PL- Consultation- West Sussex Fire & Rescue Service response

From: Amber Willard <Amber.Willard@arun.gov.uk>
Sent: 09 February 2026 08:12
To: Planning.Responses <Planning.Responses@arun.gov.uk>
Subject: FW: Planning Consultation on: BN/10/26/DOC Land East of Croft Surgery, Barnham Road, Eastergate PO20 3RP

Application No: BN/10/26/DOC
Registered: 4th February 2026
Site Address: Land East Of The Croft Surgery Barnham Road Eastergate PO20 3RP
Description of Works: Approval of details reserved by condition under BN/38/24/PL relating to conditions 5, 7, 16, 19, 20, 21, 22, 23 & 24. (See Application BN/12/26/DOC for conditions 8 & 9 - drainage).

SITE:
THE CROFT,
BARNHAM ROAD, EASTERGATE,
PO20 3RP
WATER CONSTRUCTION PLAN

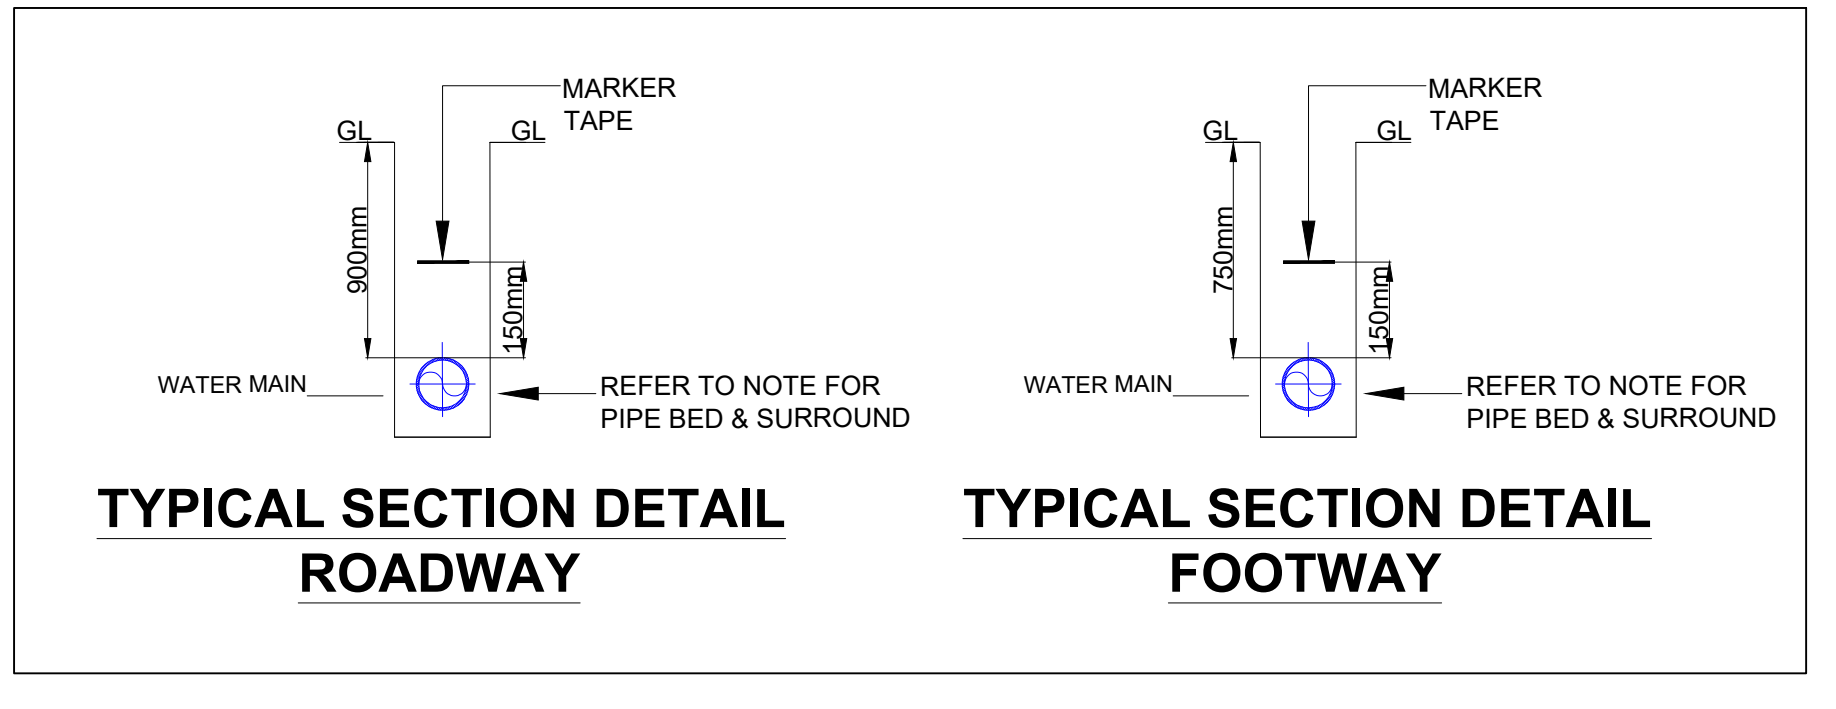
Having viewed the details for planning application No. BN/10/25/DOC for the discharge of the fire hydrant condition, providing the fire hydrant indicated on the plan submitted is in place, supplied by the water main size identified (minimum 90mm), ready for use and West Sussex Fire & Rescue Service are informed it is ready for operational use, the condition will be met and the condition discharged. Unfortunately, on too many occasions new housing estate properties are occupied prior to WSFRS being informed fire hydrants are ready for use, which then puts lives and properties at increased risk in the event of a fire, and this condition is rarely followed up if FHs are not ready for use in all respects prior to any occupation of any dwellings on site.
